LAND SOUTH OF GREVATTS LANE/ A259 – PROPOSED GOLF COURSE ACCESS

Stage 1 Road Safety Audit – Designers Response

JNY10830-10
RSA 1 Designers
Response
Version 2
29 July 2022

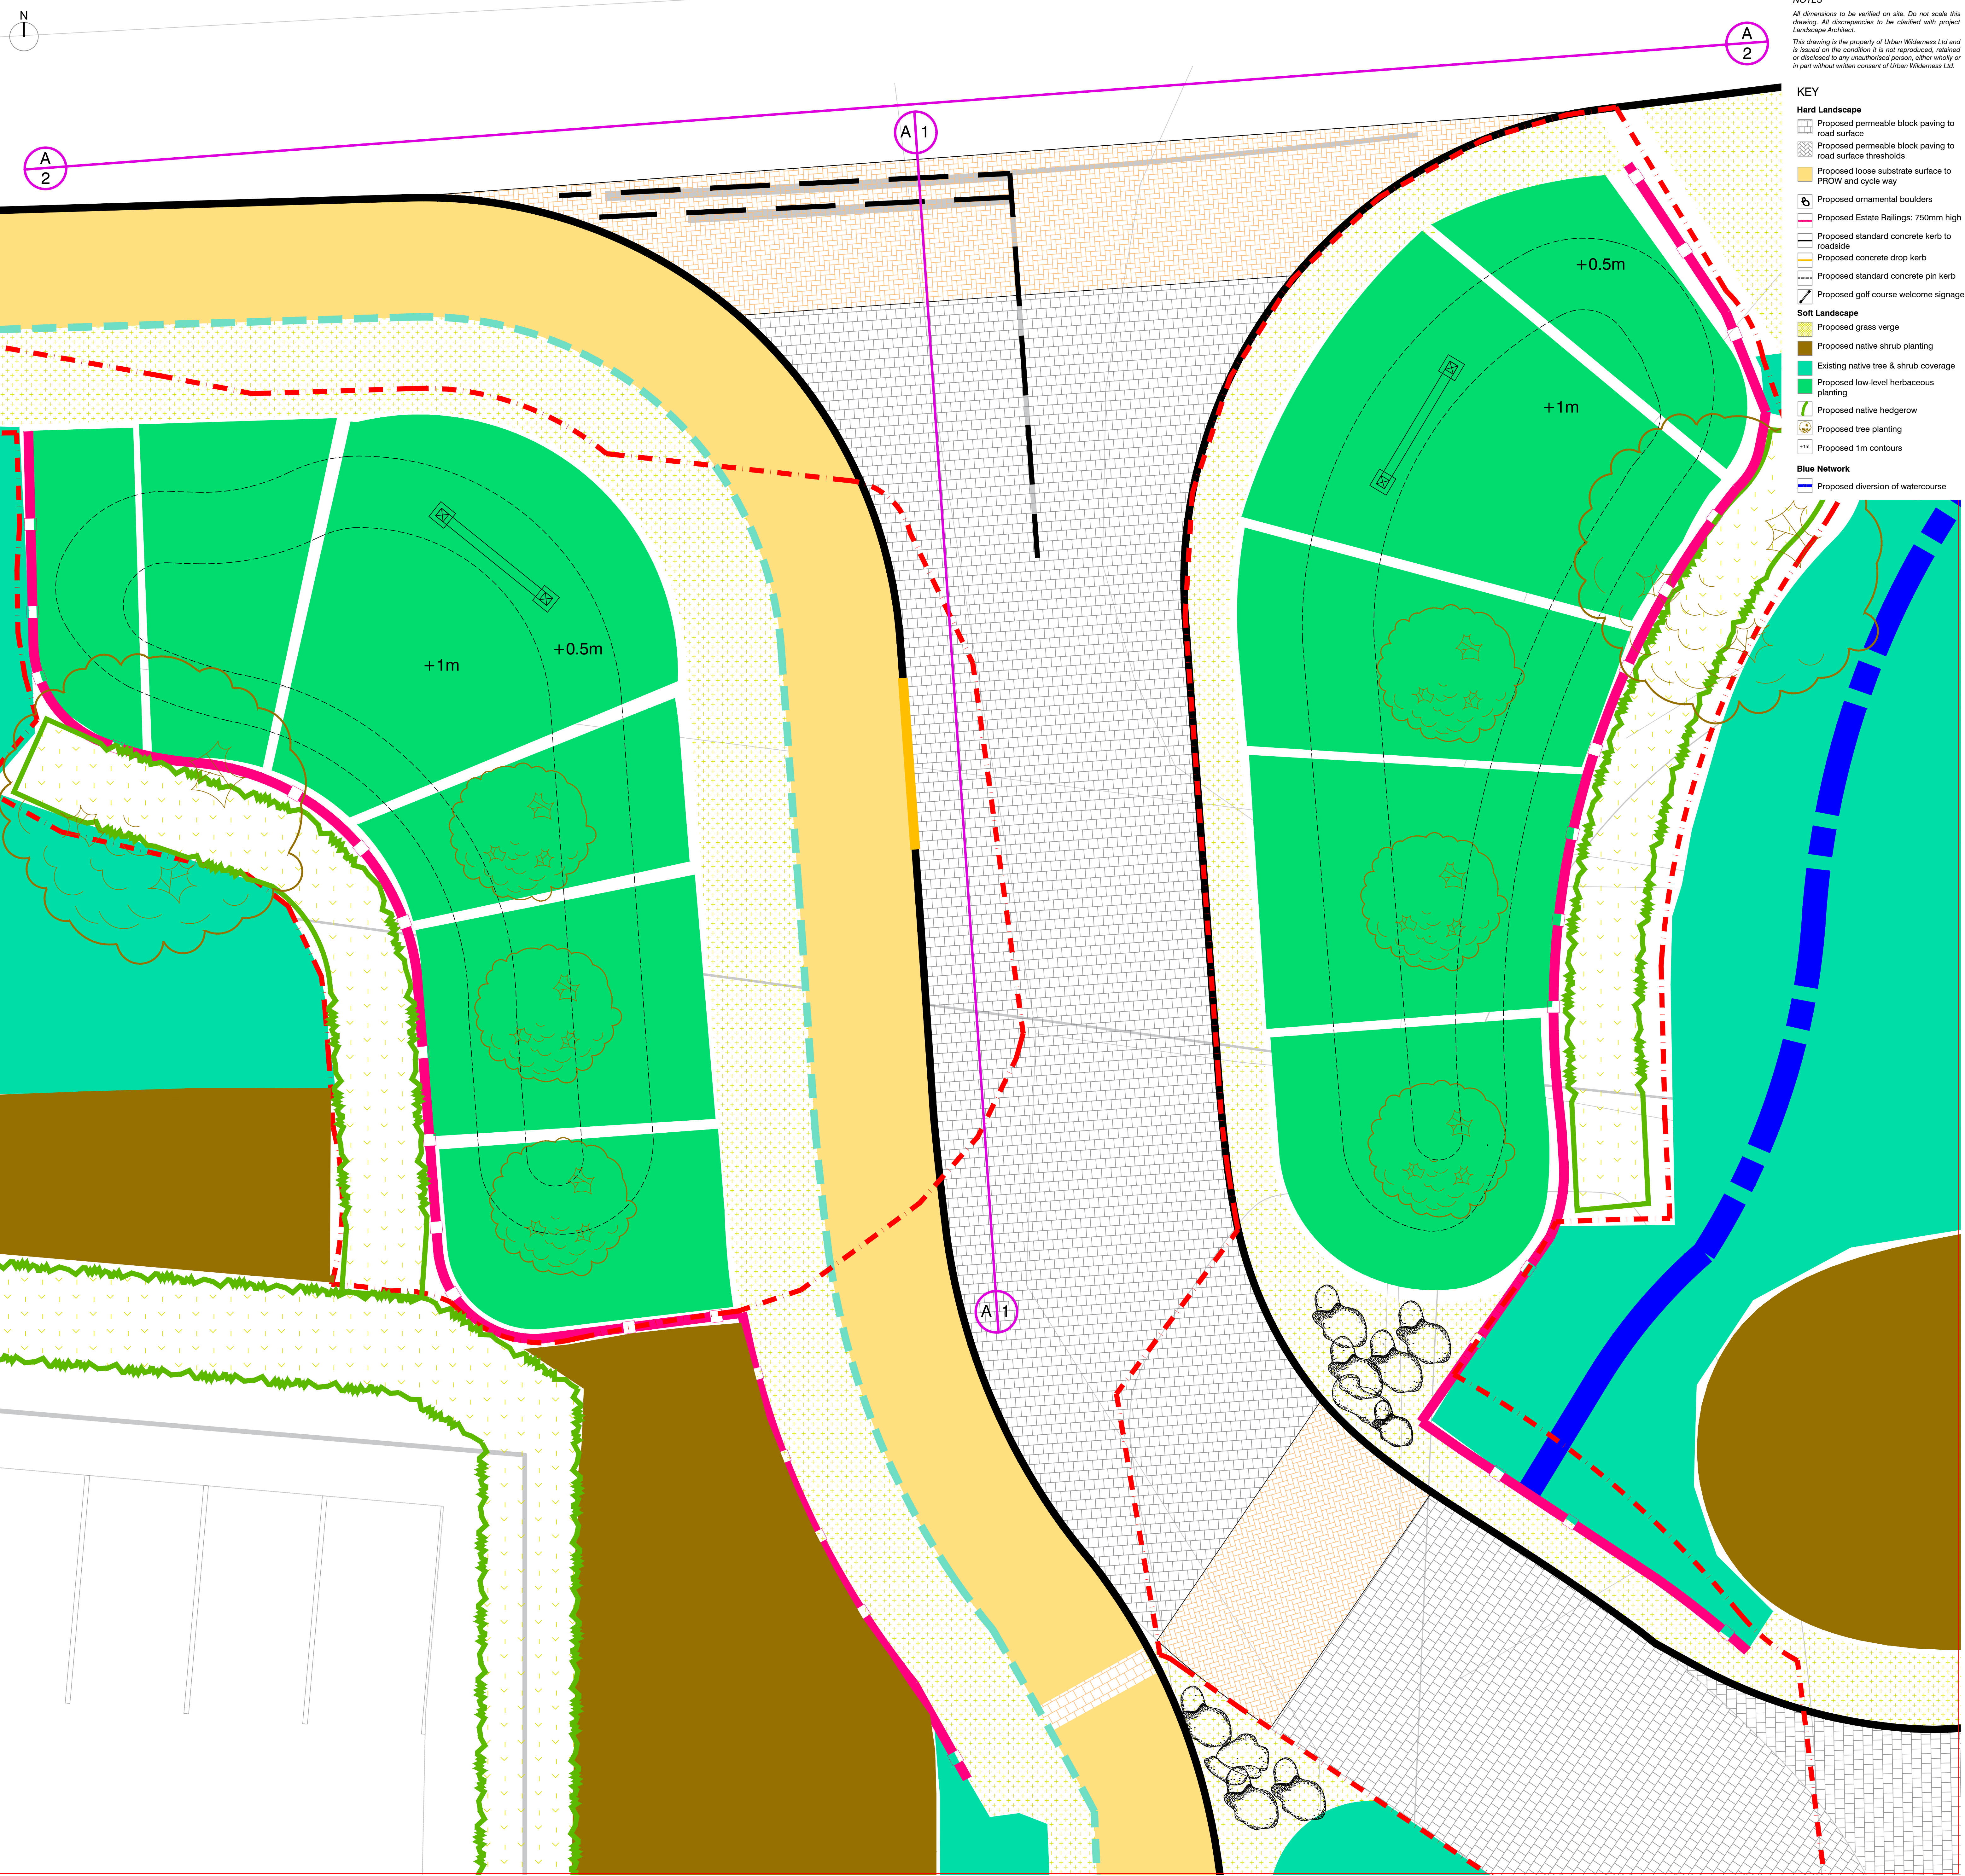
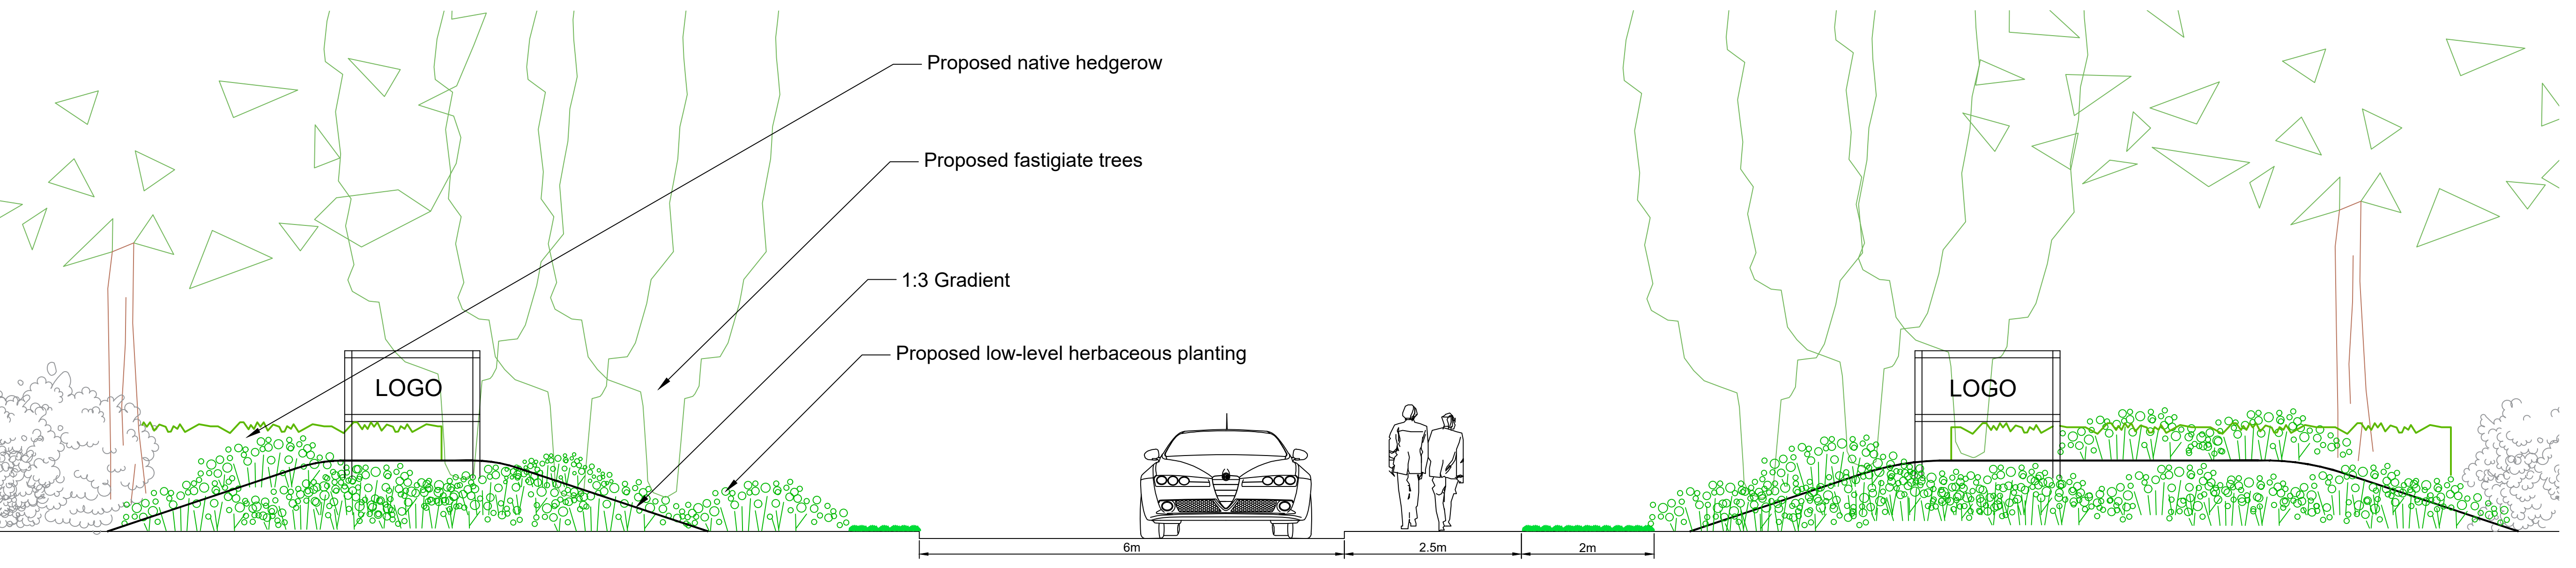
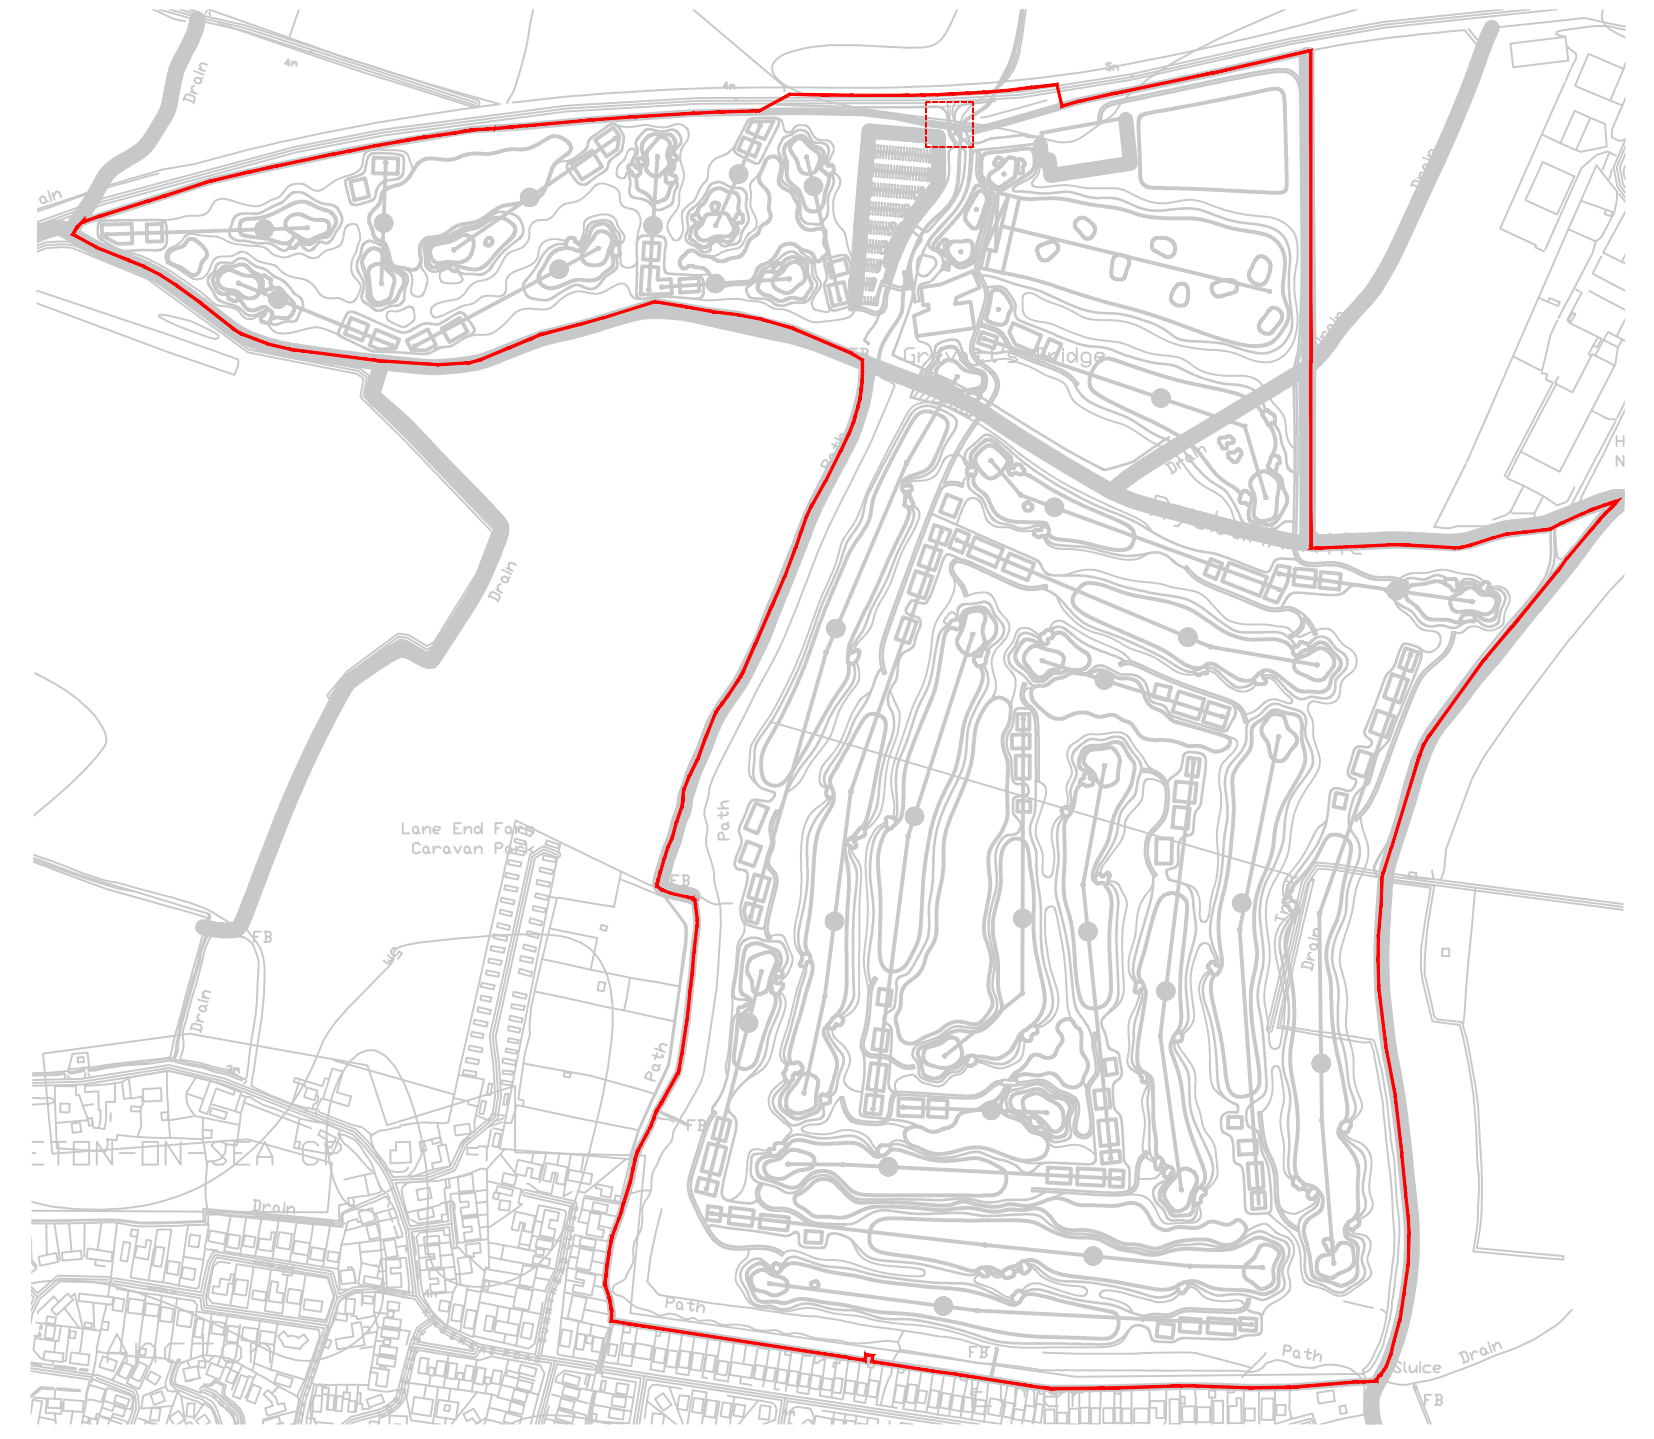
AUDIT REF	Problem Summary and Recommendation	Designers Response	WSCC Comments	Agreed RSA Action
3.1 - 1	Summary – Abrupt westbound kerb line may increase the risk of kerb strikes and single vehicle loss of control type collisions. Detail – The kerb line to the west of the Golf Course access appears to have an abrupt alignment adjacent to the proposed pedestrian refuge and at the exit taper tie-in to the existing kerb line. This may increase the risk of strikes and single vehicle loss of control type collisions. Recommendation – the Audit Team recommend that the proposed westbound southern kerb line ties into the existing kerb line using a smooth transition.	The layout has been amended in line with the recommendation provided. The layout also includes for link to the proposed crematorium access approximately 450m west of the proposed site.	Accept recommendation and Design Organisation's response to it.	Auditor Design That as part of the detailed design, the proposed westbound southern kerb line ties into the existing kerb line using a smooth transition.
